A57 Link Roads

TR010034

March 2022

9.61 Register of Environmental Statement Changes

Drawing Title
**FIGURE 11.13
 OPERATION PHASE LONG TERM CHANGE
 WITHOUT THE SCHEME (DSFY-DMOY)**

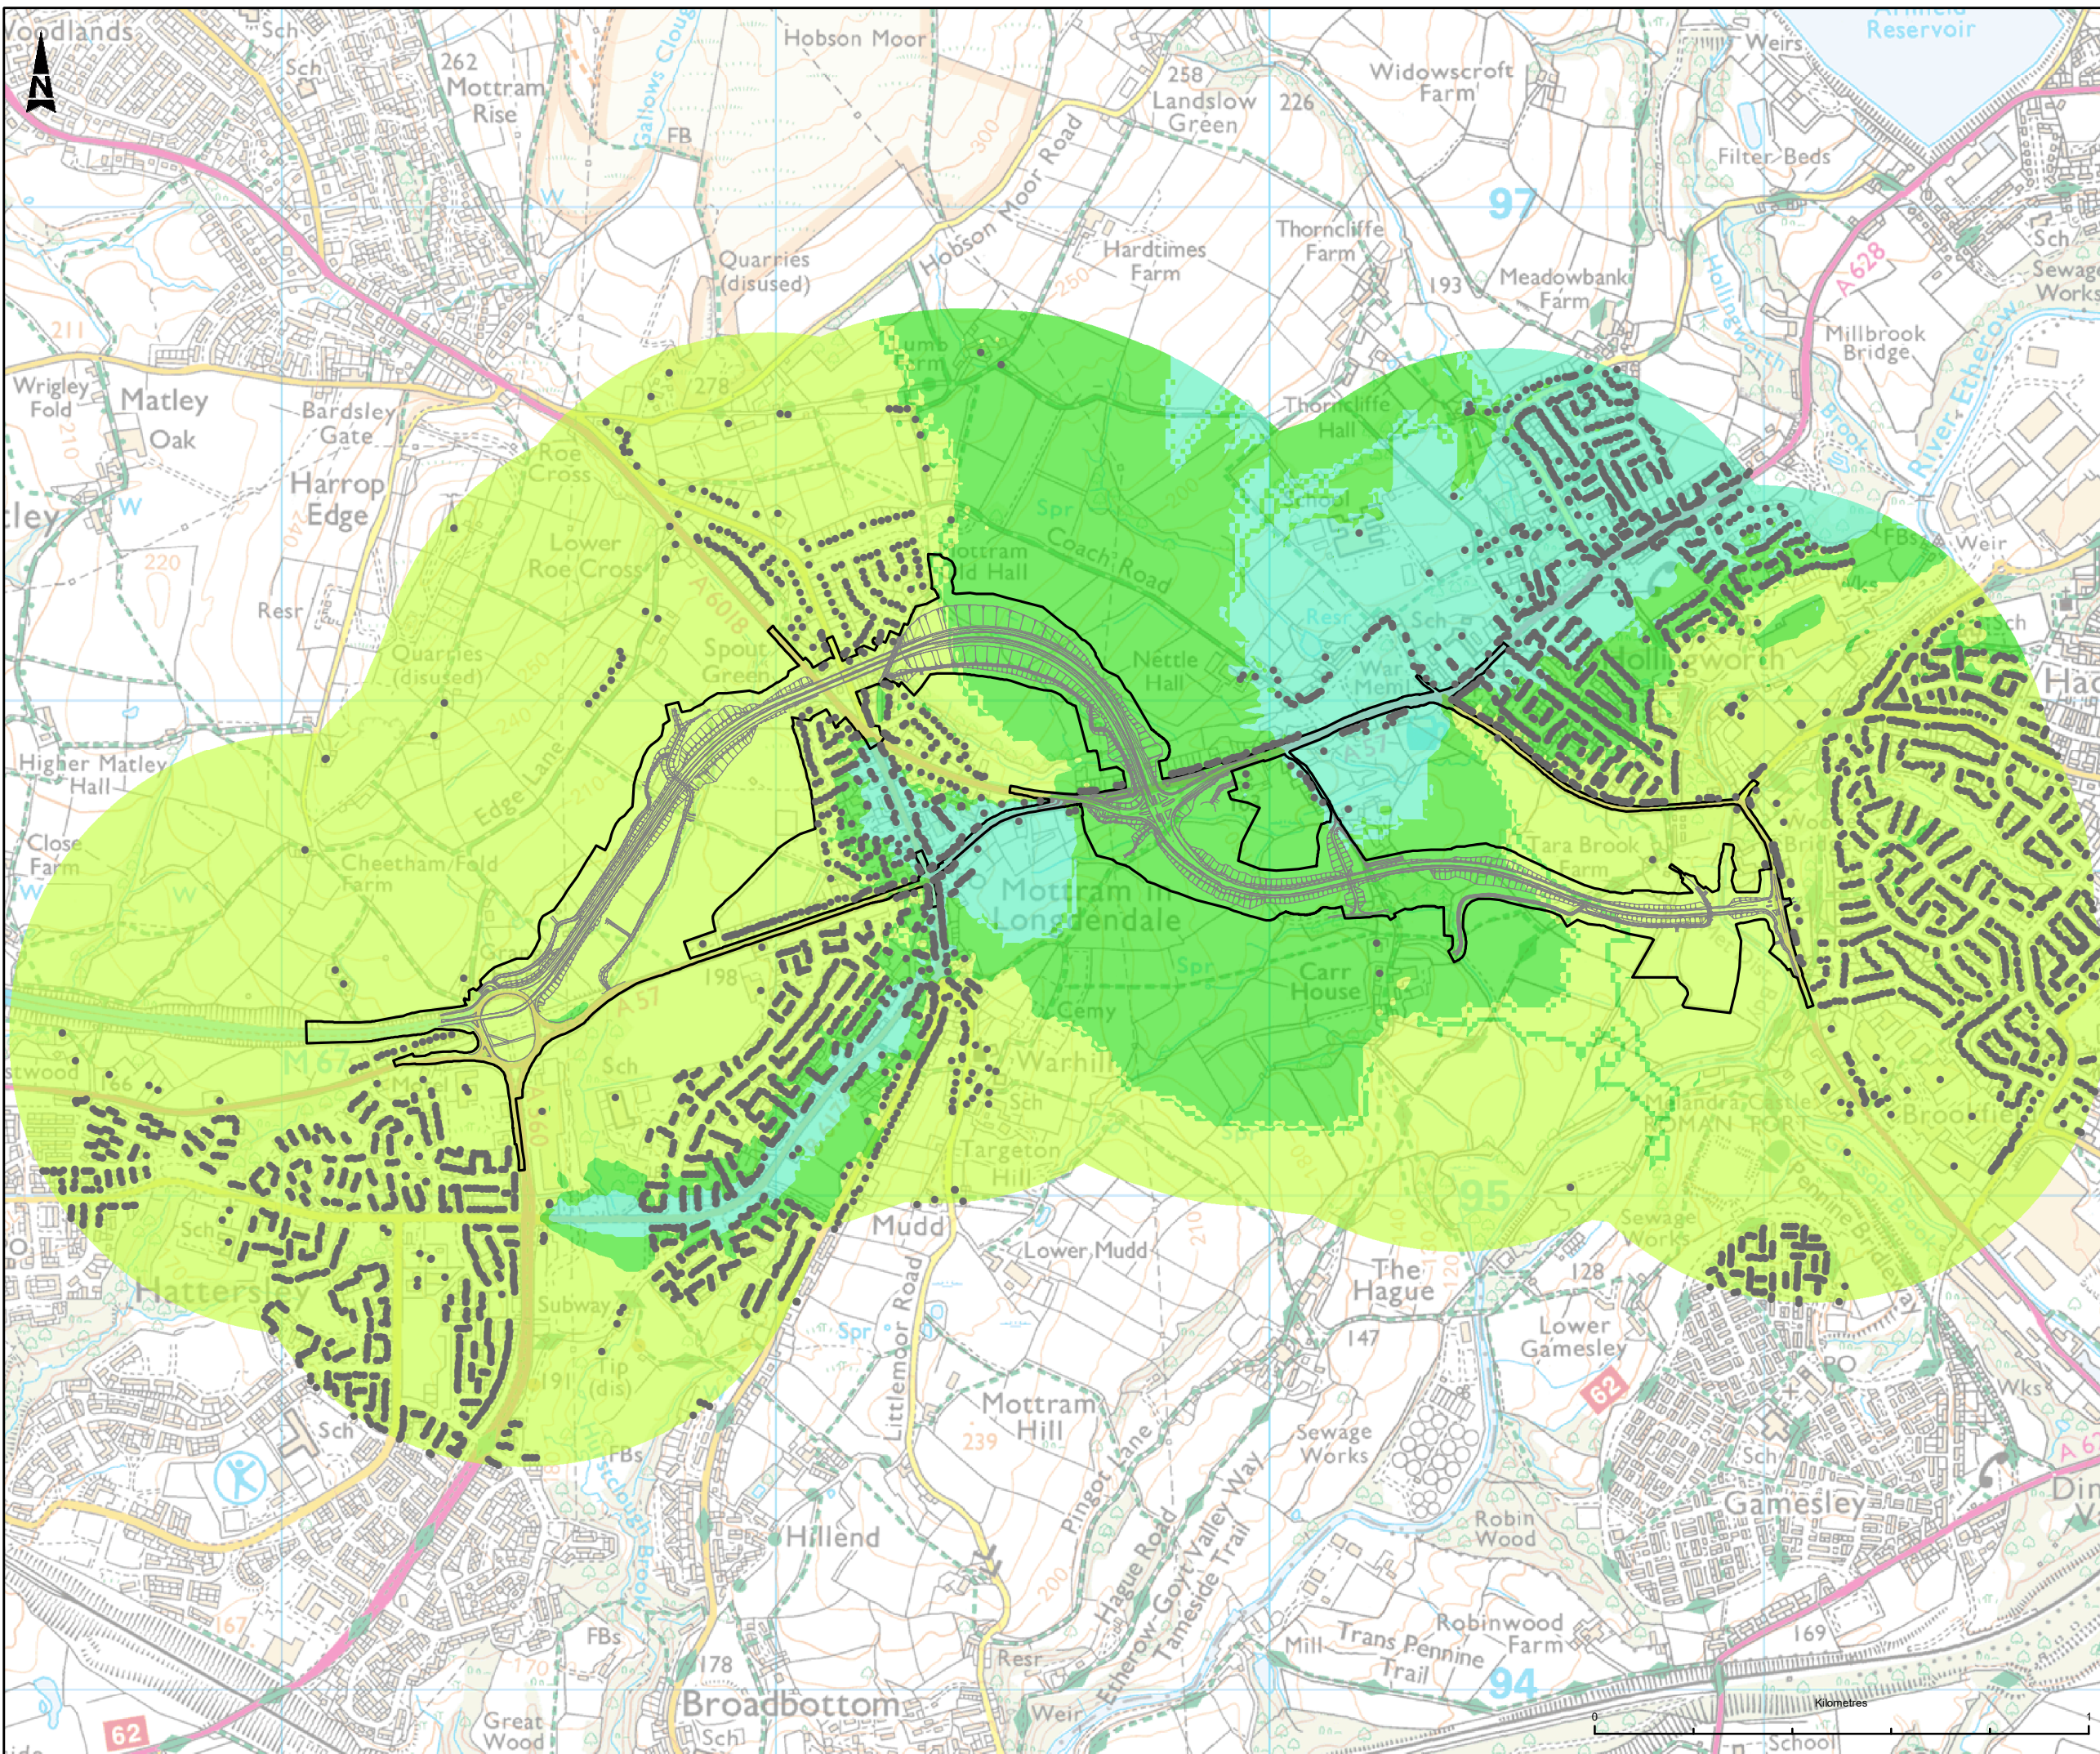
Environmental Statement - Figure 11.13 - Operation Phase Long Term Change without Scheme (DSFY-DMOY)	REP1-028	Updates to ensure Title aligns with data in images	2
Environmental Statement - Figure 11.14 - Operation Phase Do Minimum Opening Year Night Noise Levels	REP1-029	Updates to figure legend to correct errors	2
Environmental Statement - Figure 11.15 - Operation Phase Do Something Opening Year Night Noise Levels	REP1-030	Updates to figure legend to correct errors Length of noise barriers updated to align with the design drawings (2.3 Works Plans) submitted	2
Environmental Statement - Figure 11.16 - Operation Phase Do Minimum Future Year Night Noise Levels	REP1-031	Updates to figure legend to correct errors	2
Environmental Statement - Figure 11.17 - Operation Phase Do Something Future Year Night Noise Levels	REP1-032	Updates to figure legend to correct errors Length of noise barriers updated to align with the design drawings (2.3 Works Plans) submitted	2
